Engineering Report: Assessment of Surface Water Runoff from Proposed Green Hill Solar Farm (Green Hill G)

Date: 19 October 2025

Subject: Preliminary Opinion of Surface Water Runoff and Contribution to Localised Flooding from the Proposed Green Hill Solar Farm (Green Hill G)

Title: Figure 3.1.8 Location Plan
Green Hill G

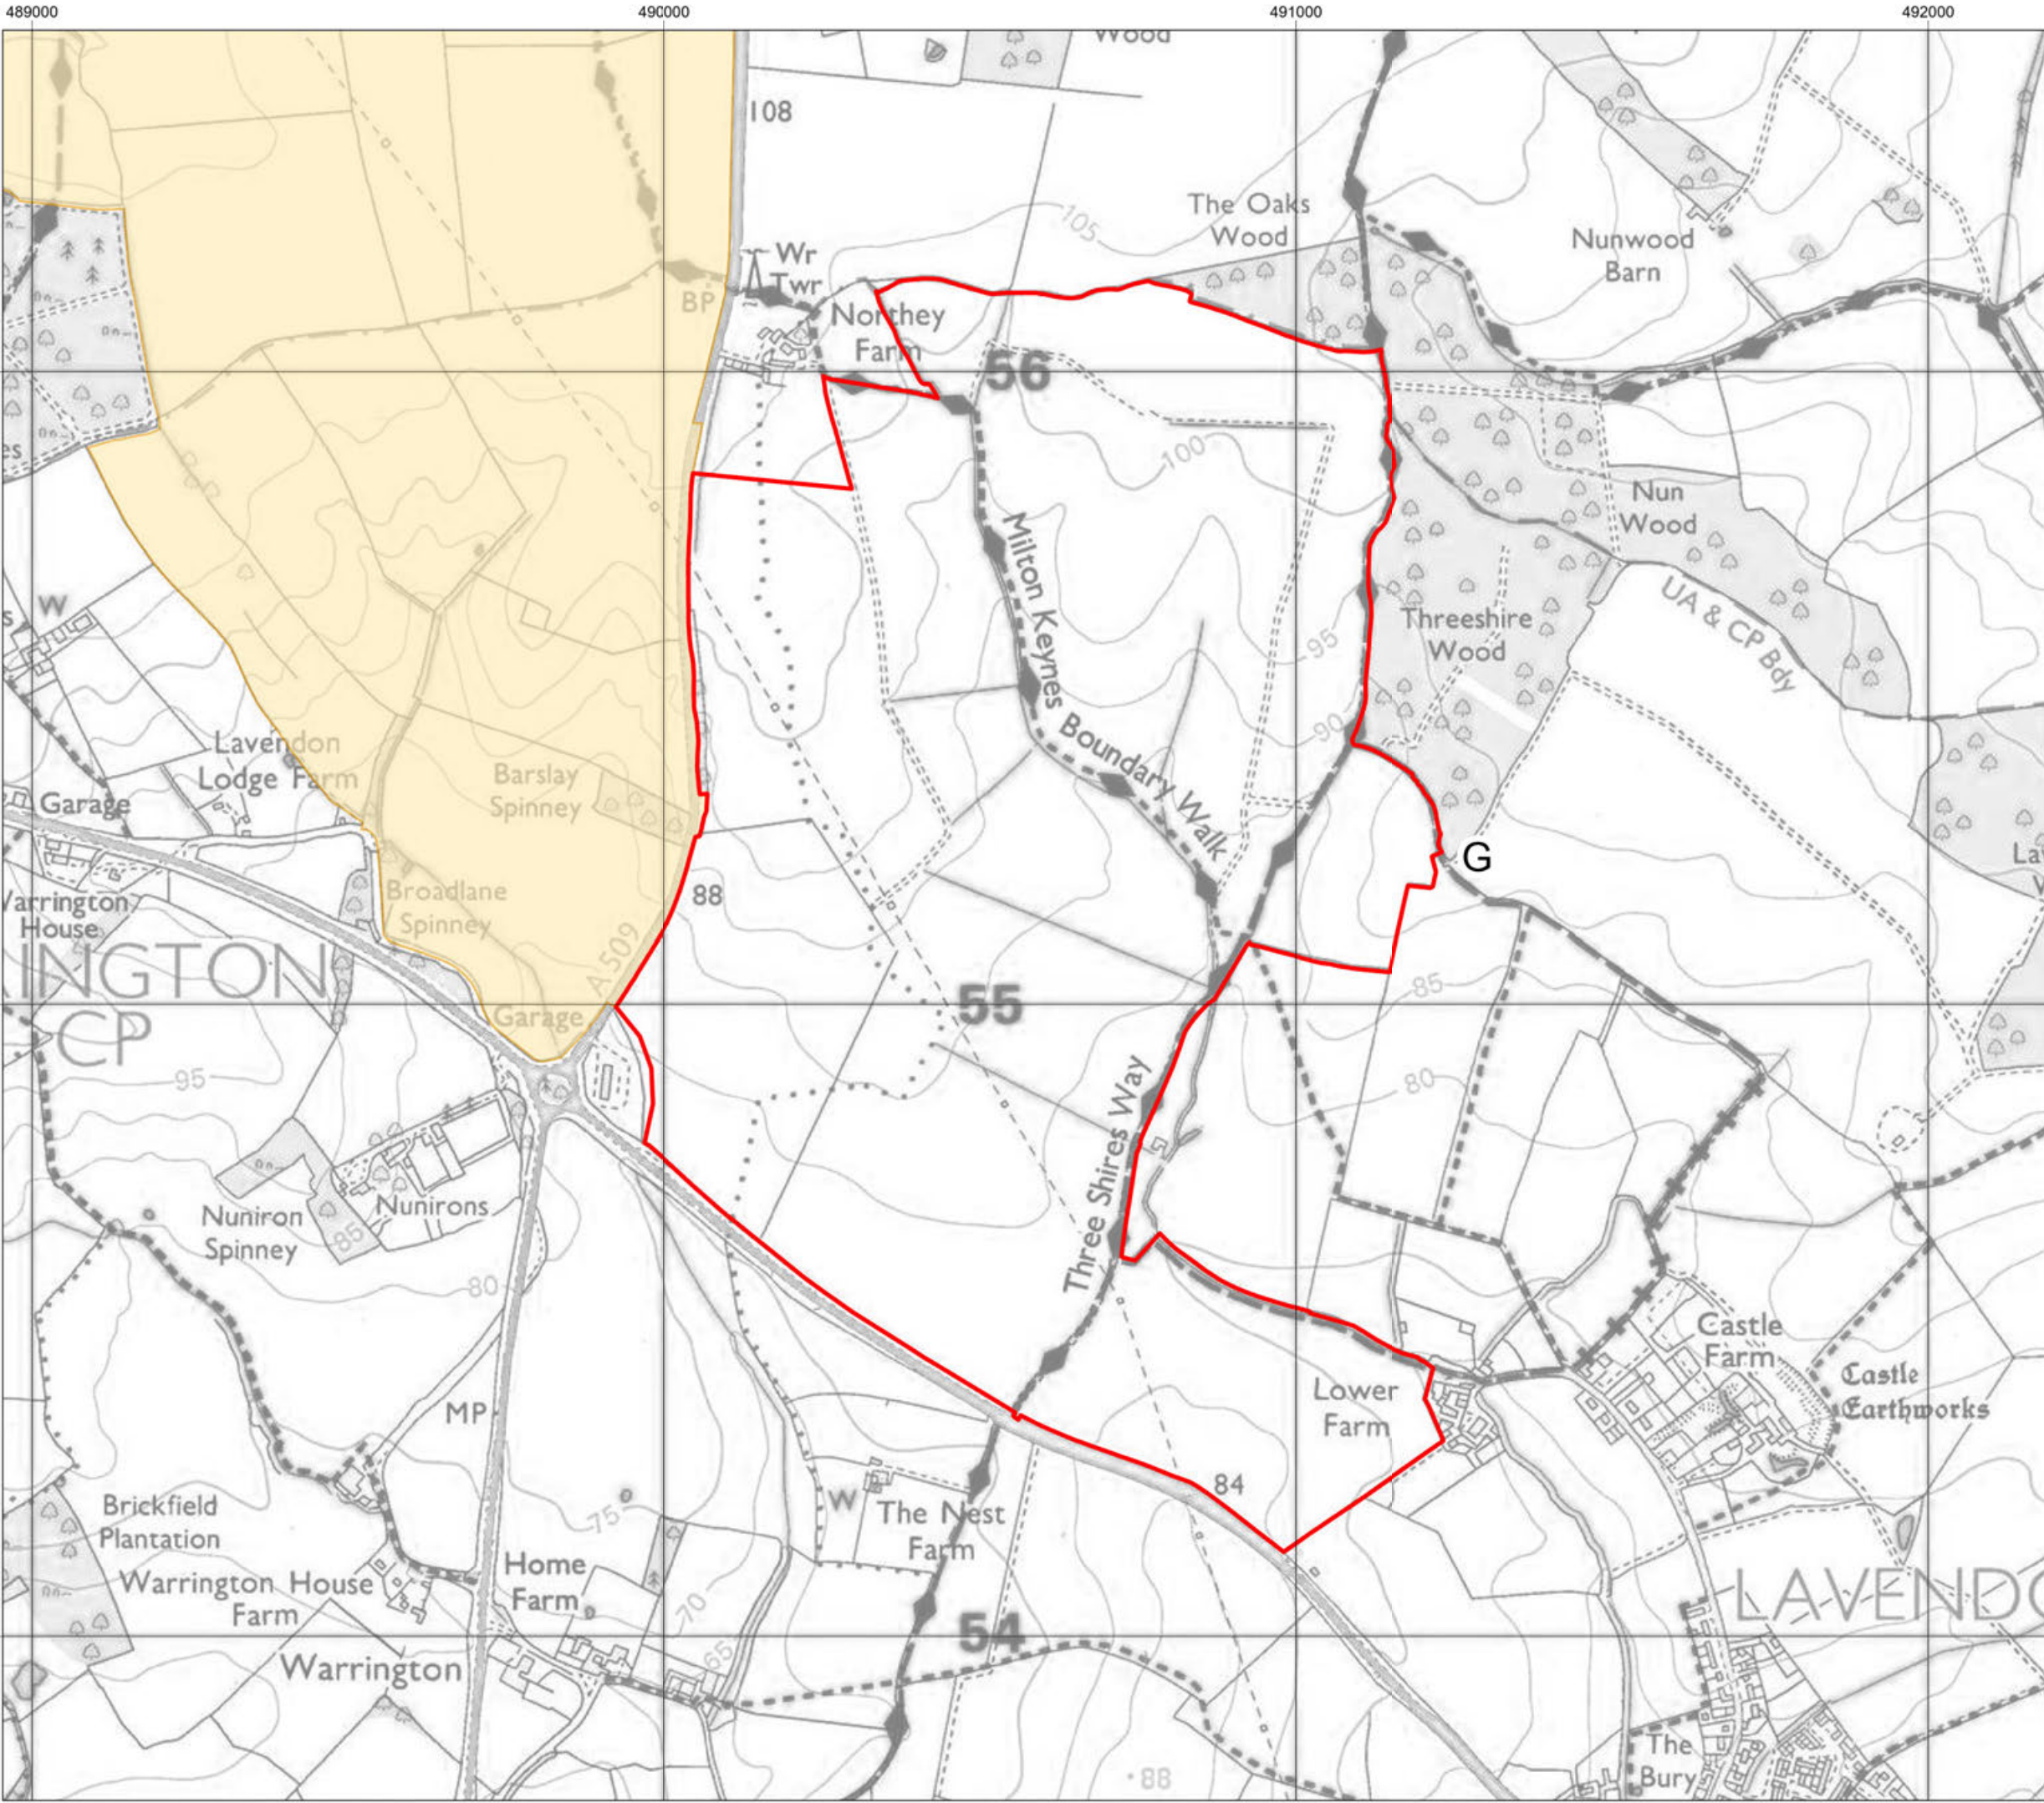
9.4.59	Green Hill G is therefore considered to be at low risk of fluvial flooding; the proposed solar panels will be raised above surrounding ground levels with associated power infrastructure appropriately located out of the flood zone and protected.	<p>Green Hill G-13 is definitely not at low risk of fluvial flooding. It appears as though the nature and extent of localised flooding (with significant impacts) has been omitted due to a blanket high-level assessment.</p> <p>See comments on alternative research concerning the actual impact of lifting solar panels.</p>
Surface Water Flood Risk 9.4.60	The EA 'Flood Risk from Surface Water' map indicates that Green Hill G ranges from a very low risk of surface water flooding (less than 0.1% annual probability) to low risk of surface water flooding (between a 1% and 0.1% annual probability) to medium risk of surface water flooding (between a 3.3% and 1% annual probability) to high risk of surface water flooding (greater than 3.3% annual probability).	The EA "Flood Risk from Surface Water" map does not take into consideration the nature and extent of parameters relevant to site G-13.

9.4.62	Based on the above and considering the embedded mitigation as part of the design of the solar panels, the overall risk of surface water flooding is considered to be Low. The proposed solar panels will be raised	Green Hill G-13 is definitely not at low risk of fluvial flooding. It appears as though the nature and extent of localised flooding (with significant impacts) has been omitted due to a blanket high-level assessment.

10.6.85	Green Hill G is therefore considered to be at low risk of fluvial flooding.	Green Hill G13 cannot be considered as being at low risk of fluvial flooding.
